TOWN AND COUNTRY PLANNING ACT 1990 FULL

Reference: H02-0996-17 **Date of Decision:** 8th December 2017
Applicant: A Nobbs
63 Peterborough Rd
Crowland
Peterborough
Cambs
PE6 0BB
Location: Land At 2 Postland Road Crowland Peterborough Cambs
Description: Proposed dwelling - re-submission of H02-0798-17

118017 / 200-01

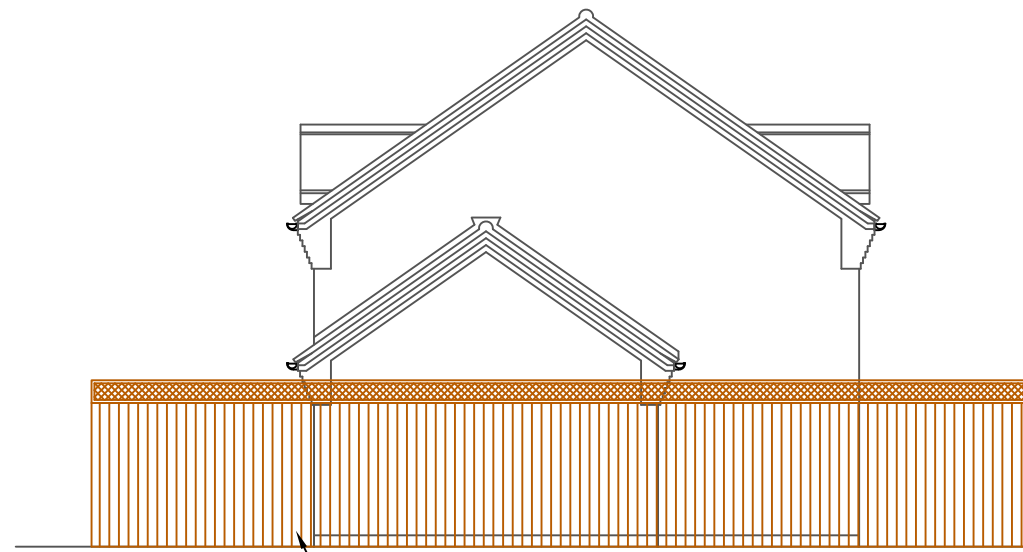
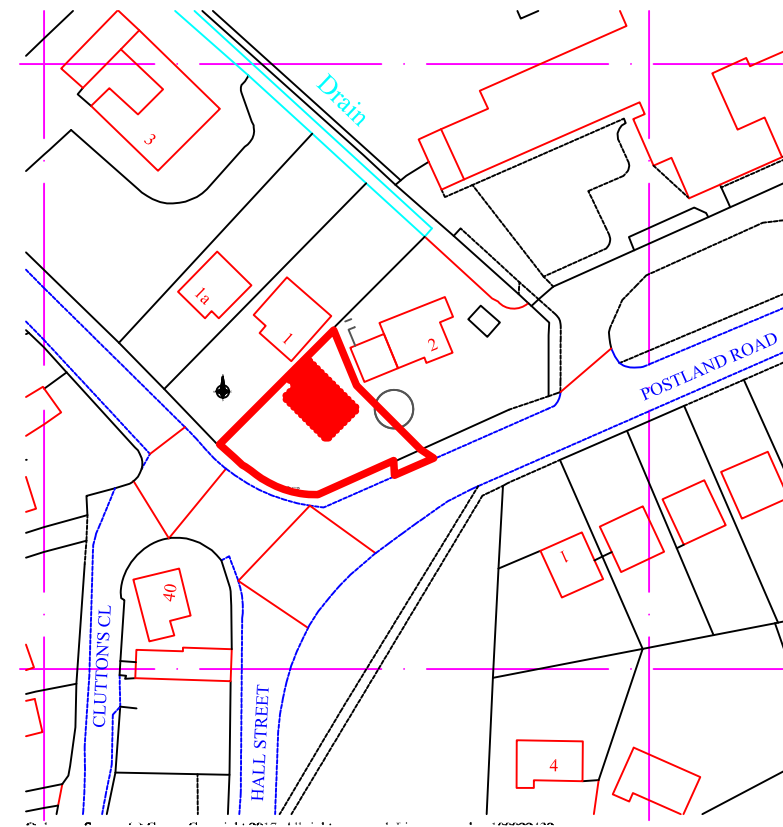
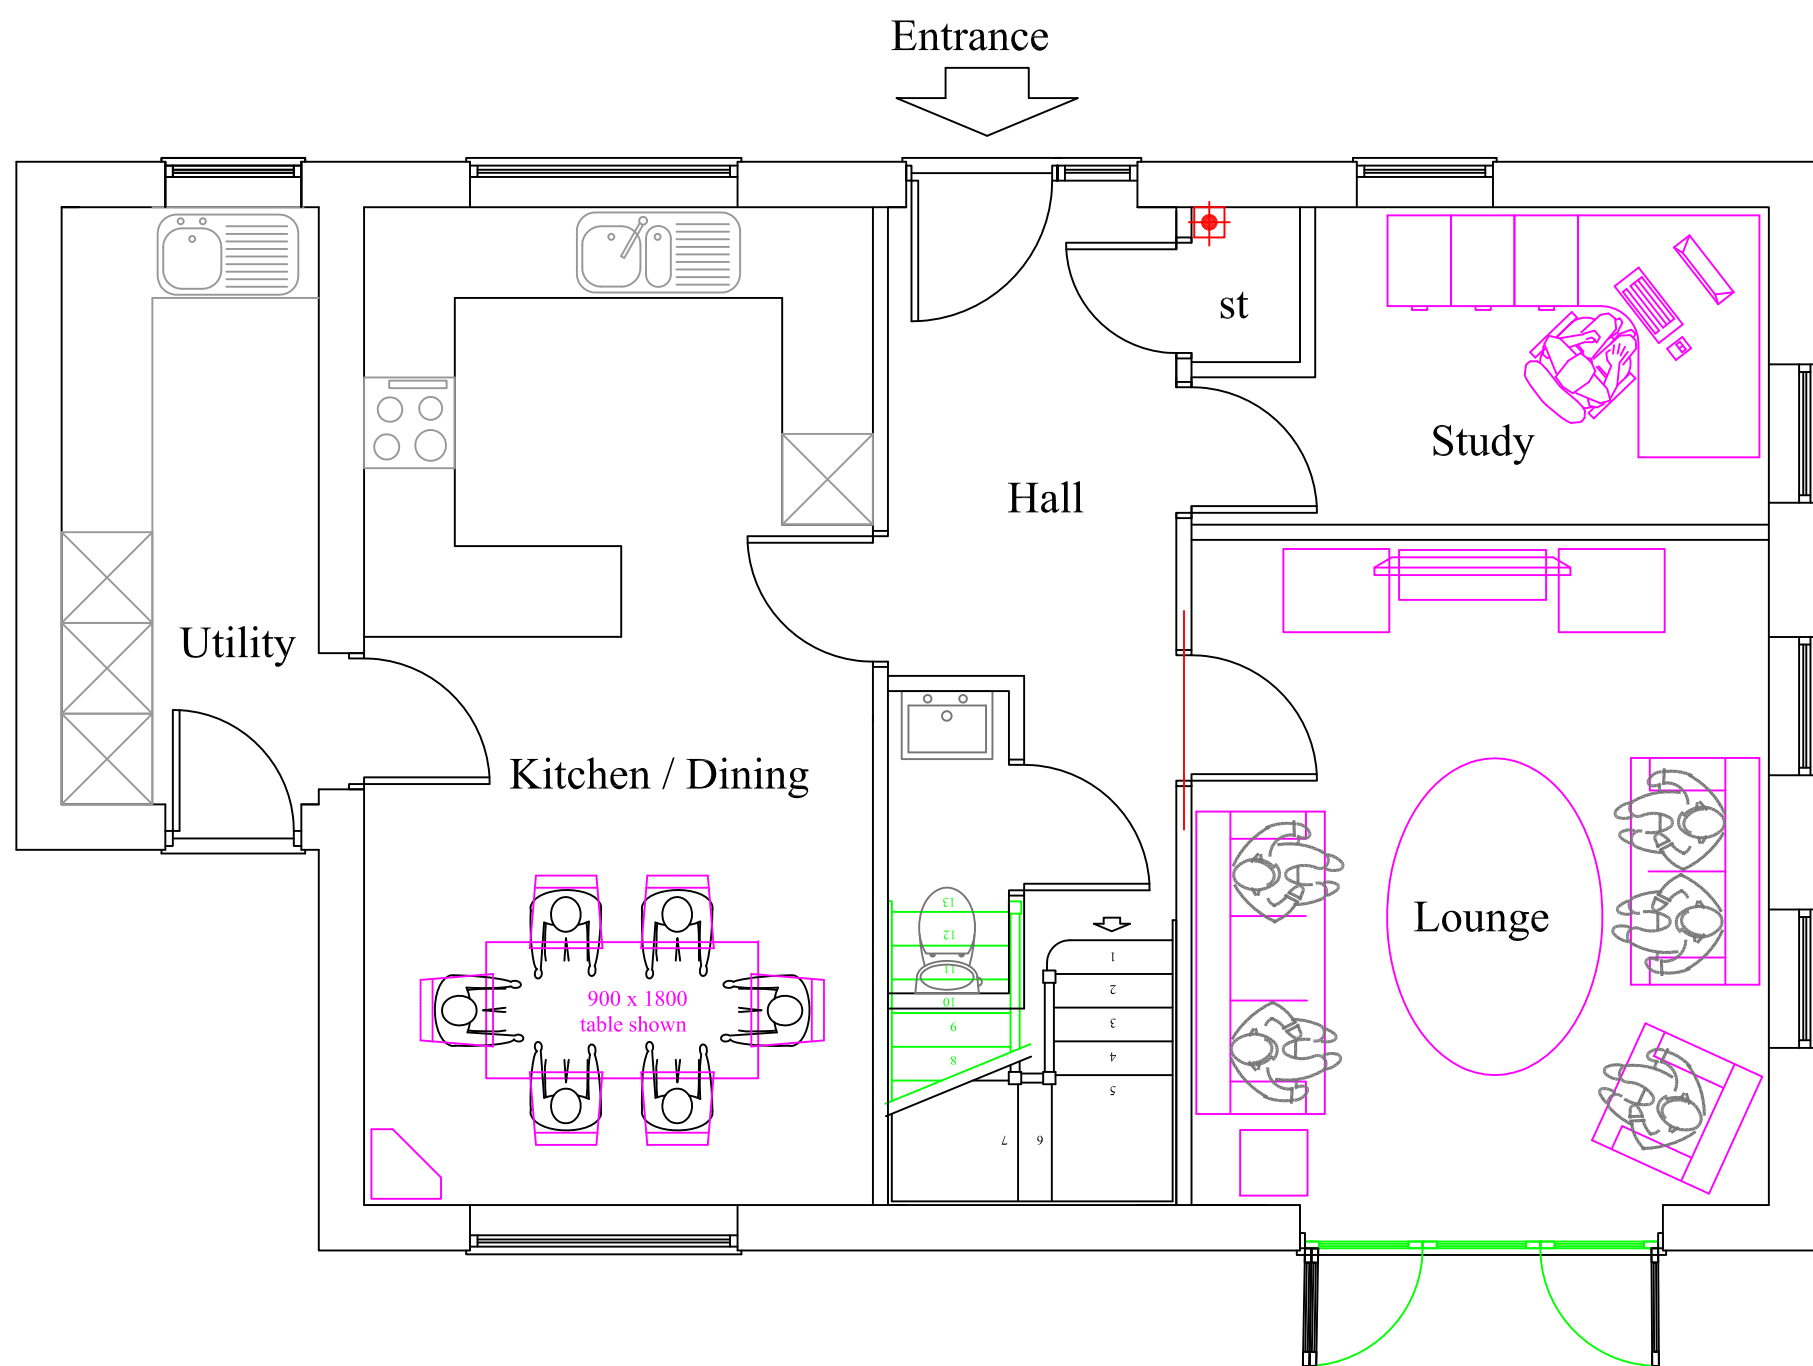
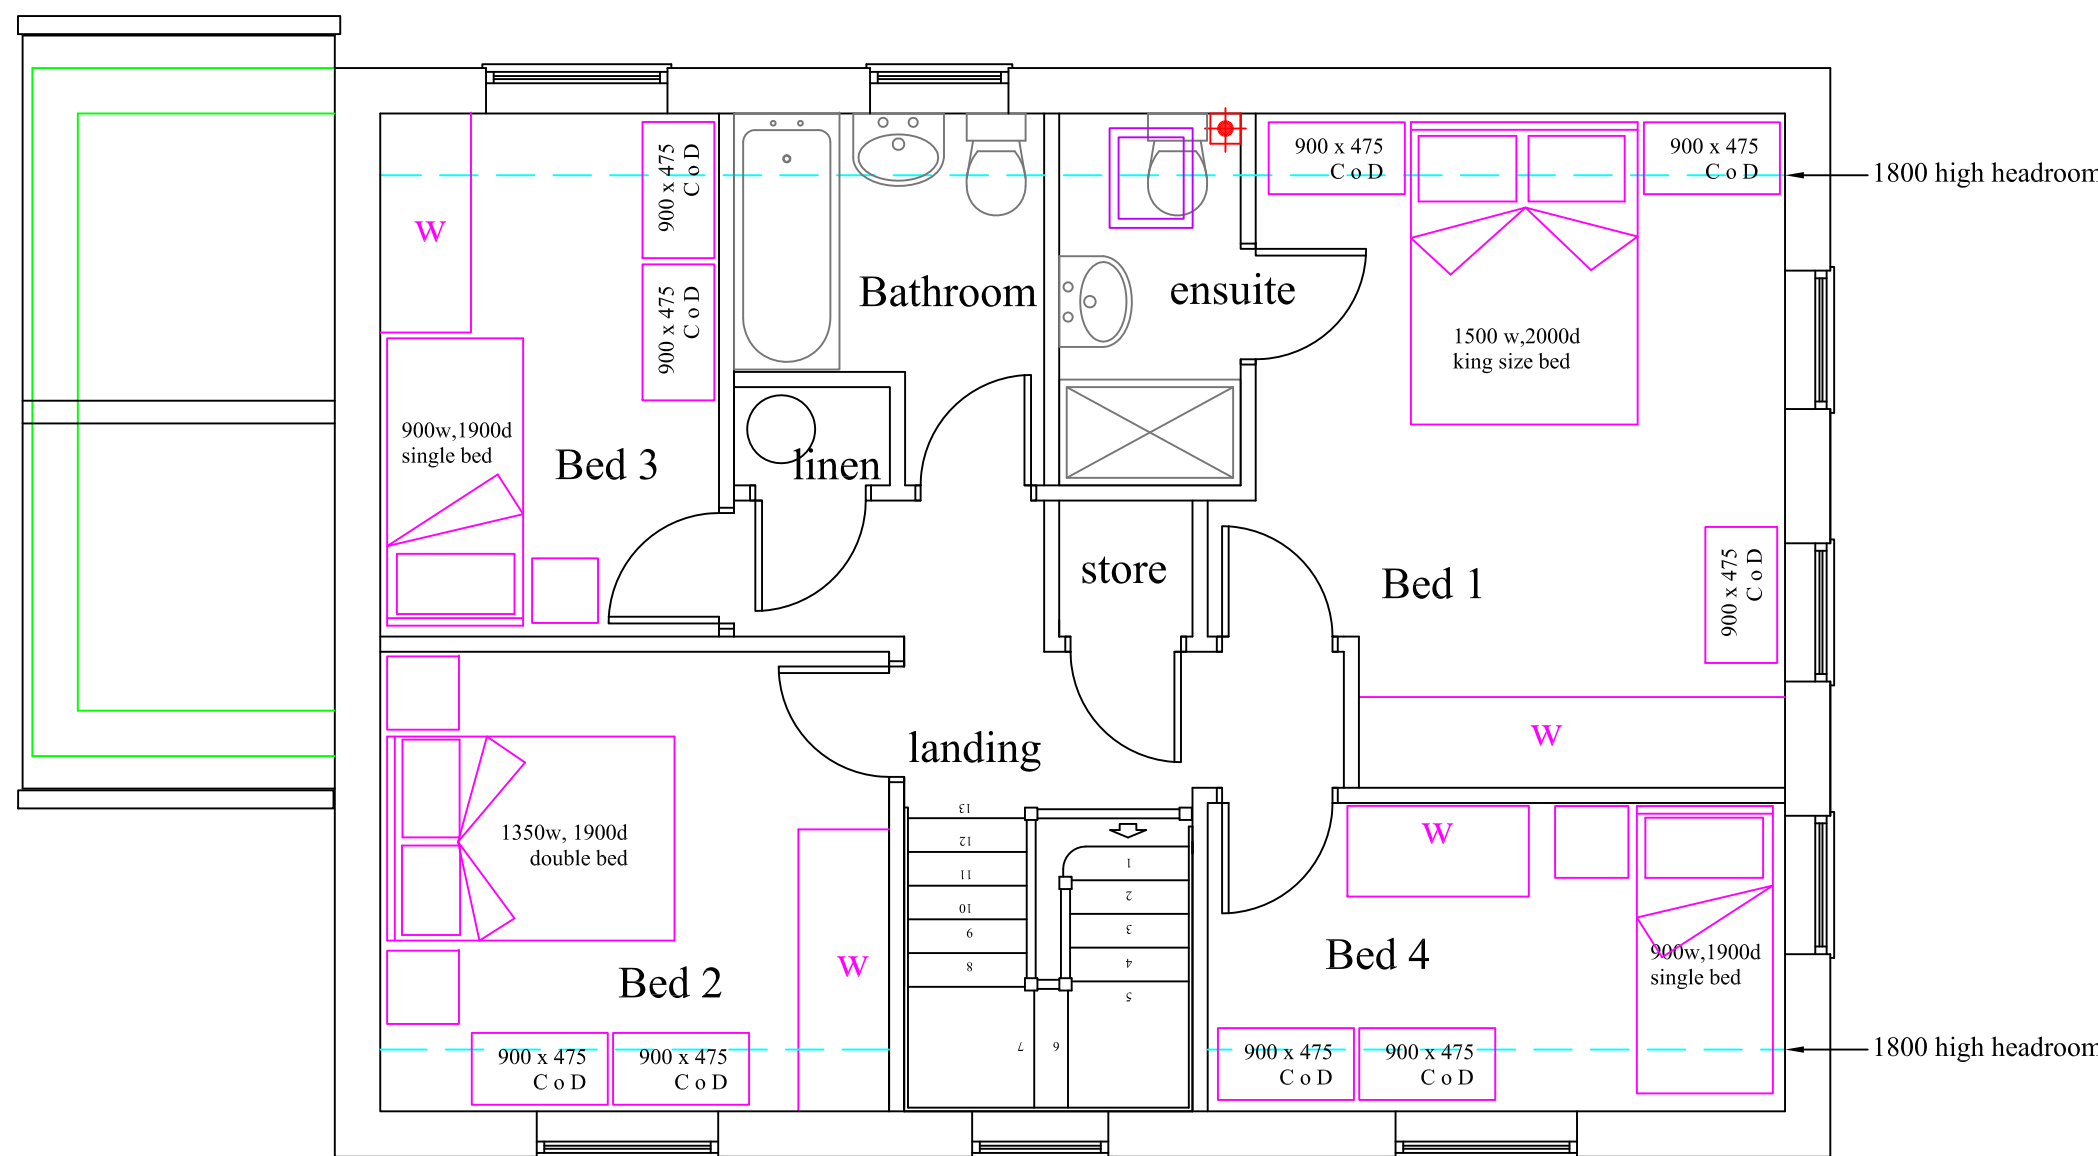
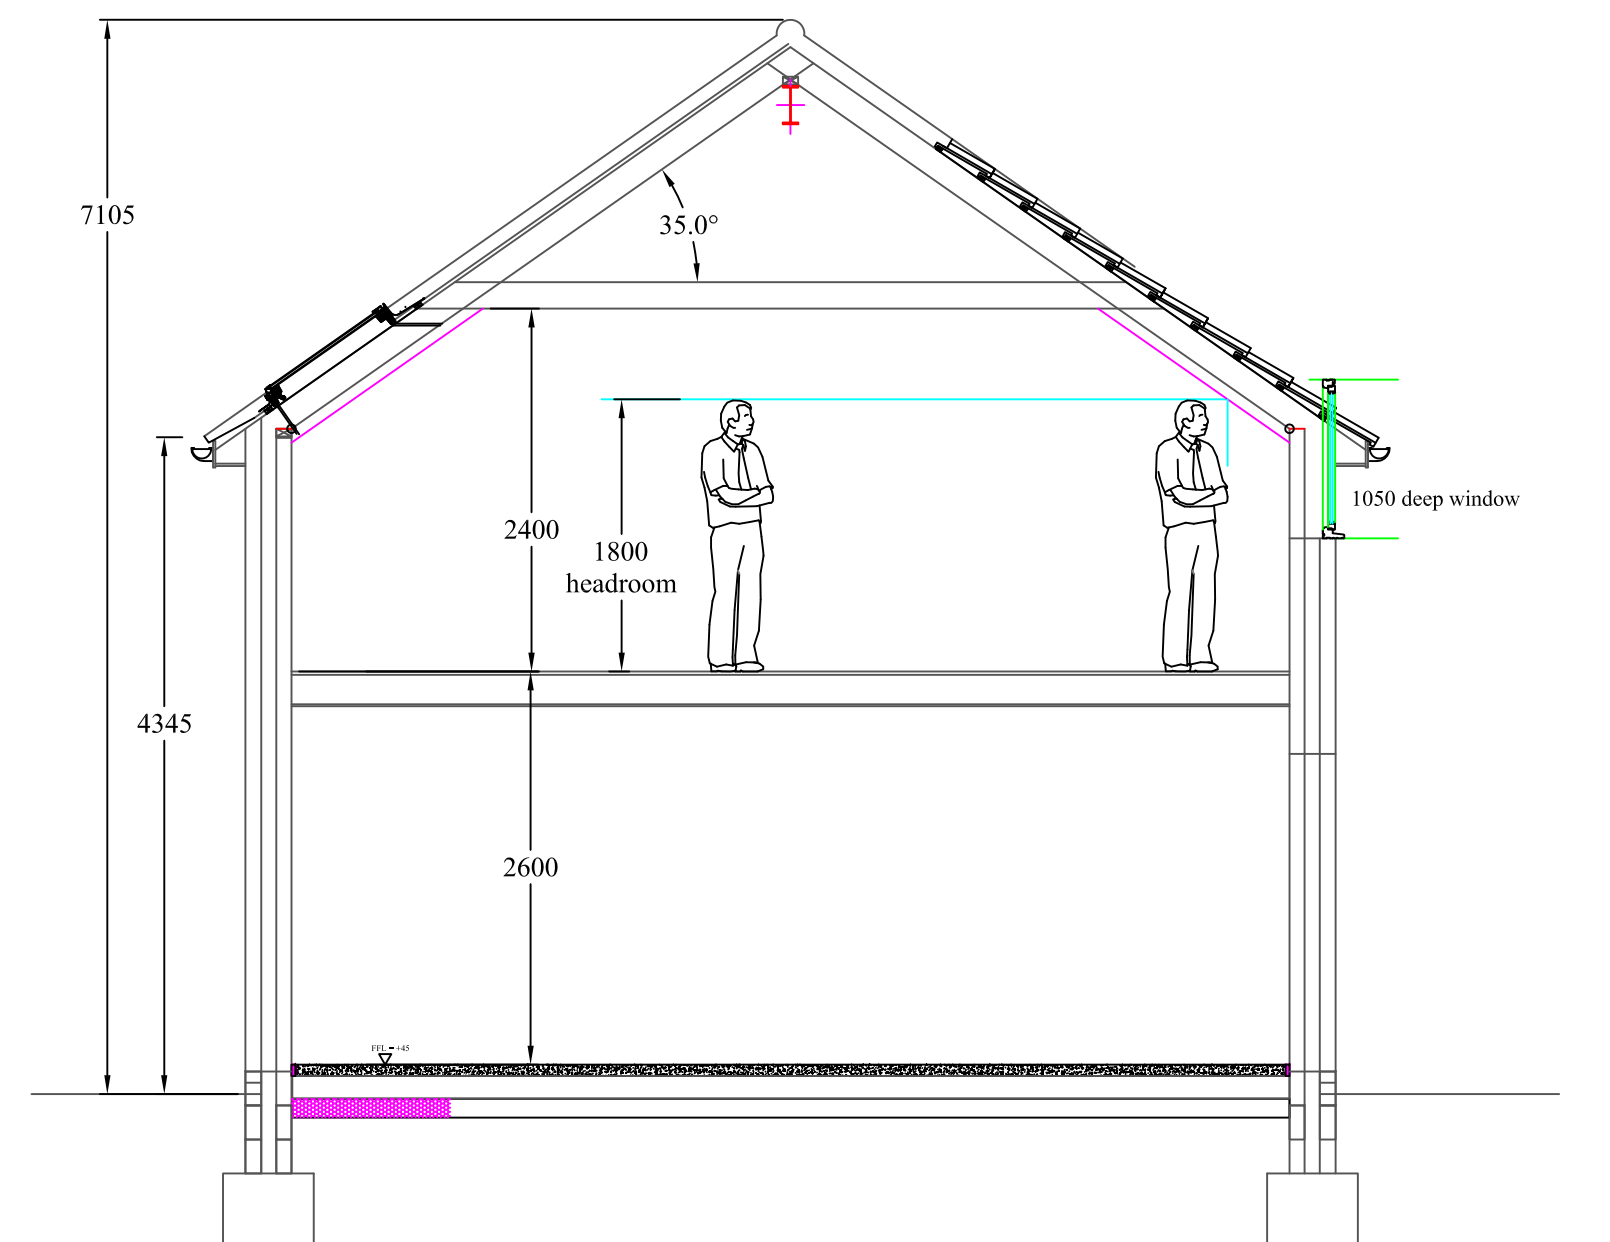
- 1 The proposal would constitute a cramped and incongruous form of development that would be at odds with the character of the surrounding area by virtue of the height of the dwelling, shape of the plot, the positioning of the proposed dwelling and its relationship with neighbouring properties. These matters are considered to have an unacceptable impact upon surrounding character and residential amenity. As such, the proposal is considered contrary to Policies HS4, SG14 and SG17 of the South Holland Local Plan, 2006. These policies indicate that new development will be permitted on suitable sites in Area Centres and should make a positive contribution to the character and appearance of the locality and not impact negatively on existing residential amenity. They are in accordance with advice within Paragraph 17 and Sections 6 and 7 of the National Planning Policy Framework, 2012.
